Office of  
Environment  
& Heritage

DOC18/329054  
SSD 8812

**Notice of Exhibition of Cranbrook School Redevelopment - SSD 8812**

## **Attachment 1 – Office of Environment and Heritage (OEH) comments Cranbrook School Redevelopment**

Sections AA-CC

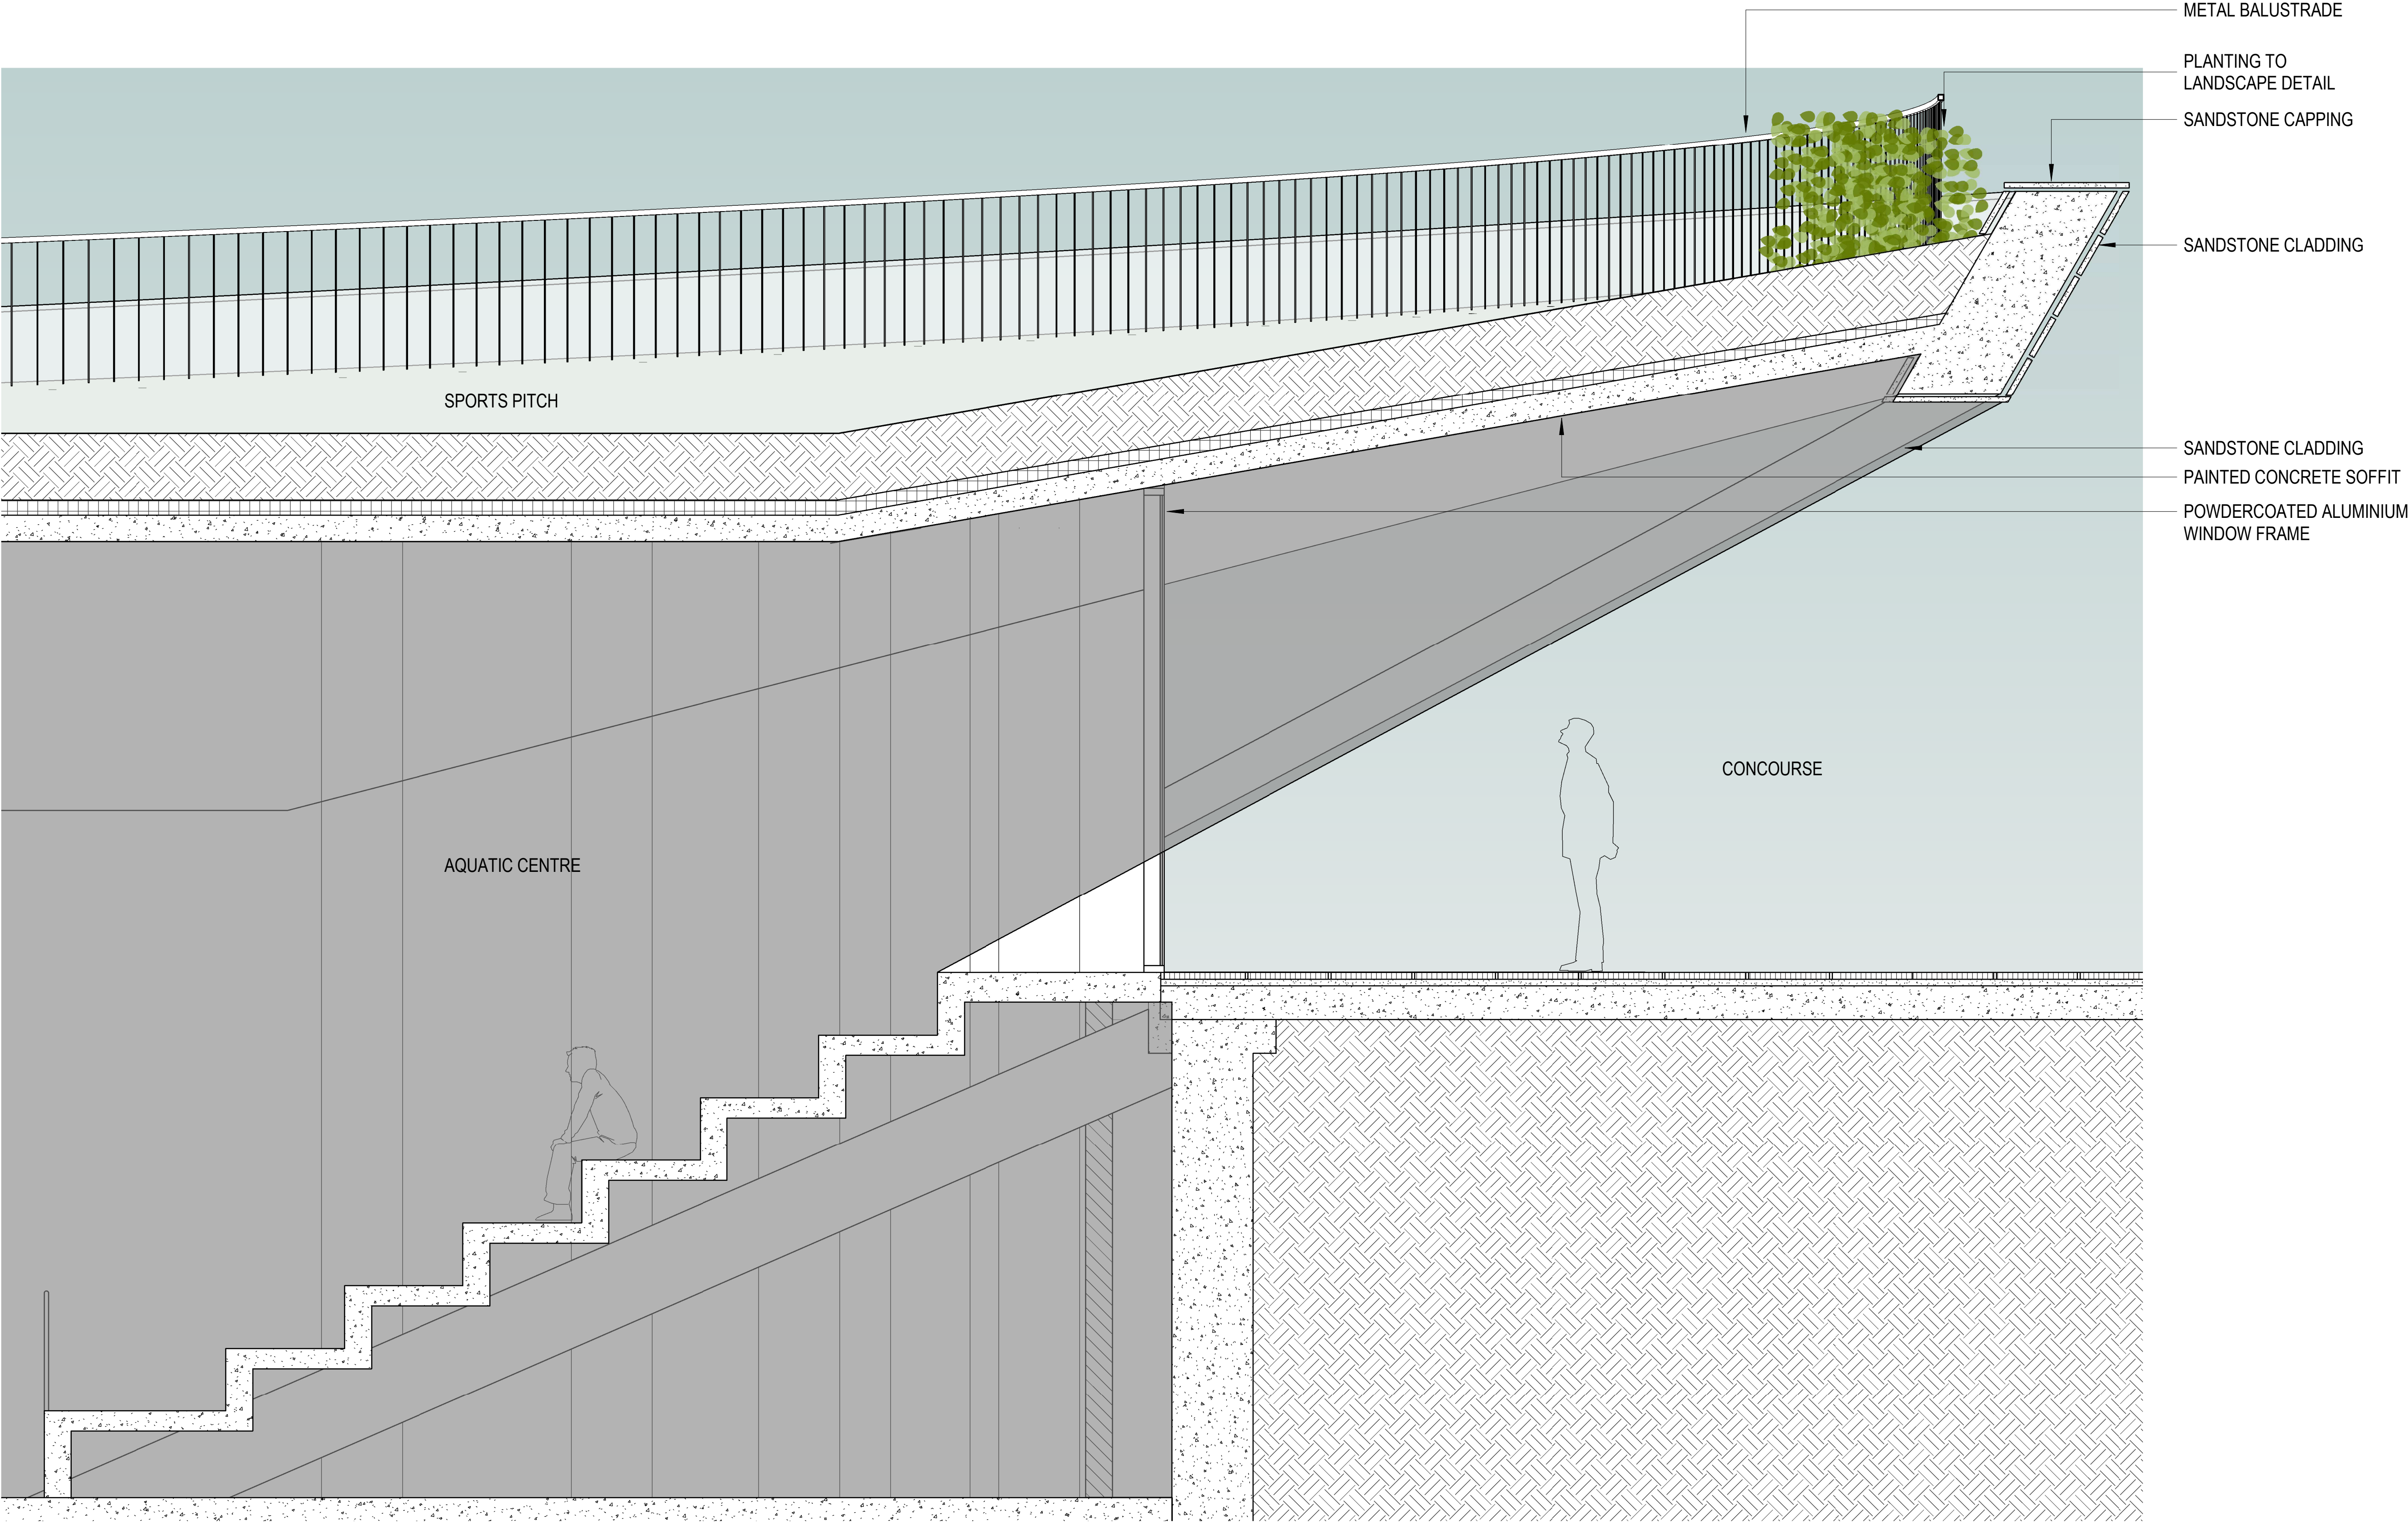
OEH has reviewed the architectural plans and EIS. It is noted that the plans show significant excavation below Cranbrook Schools existing rugby oval. This is required in order to facilitate the proposed aquatic and leisure centre comprising a 50m pool and learn to swim pool plus gym and basketball court over two levels as shown on the section plan extracted below. These two levels will be more than 8m below the ground level of the oval.

It is noted that in the proponents original SEARs request it stated that the area of the Oval was constructed of fill in the 1920s and sits approximately 2 to 3m above the local streets intersection. OEH raised no comments (email October, 2017) on the original request for SEARs, however it was unclear at this time how significant the excavation would be.

OEH considers that the scope of the excavation works is significant, extending far beyond the oval's original fill area and given there are two known Aboriginal sites within 1km of the site (EIS reference section 6.11.2), OEH recommends that an Aboriginal Cultural Heritage assessment report should be undertaken to support this development.

In this regard, OEH recommends the EIS identify and describe the Aboriginal cultural heritage values that exist across the whole area that will be affected by the development. This may include the need for surface survey and test excavation. The identification of cultural heritage values must be conducted in accordance with the Code of Practice for Archaeological Investigations of Aboriginal Objects in NSW (OEH 2010), and guided by the *Guide to investigating, assessing and reporting on Aboriginal Cultural Heritage in NSW* (DECCW, 2011) and consultation with OEH regional branch officers. OEH also recommends consultation is undertaken in accordance with *Aboriginal cultural heritage consultation requirements for proponents 2010* (DECCW) and documented in the Aboriginal Cultural Heritage Assessment Report.
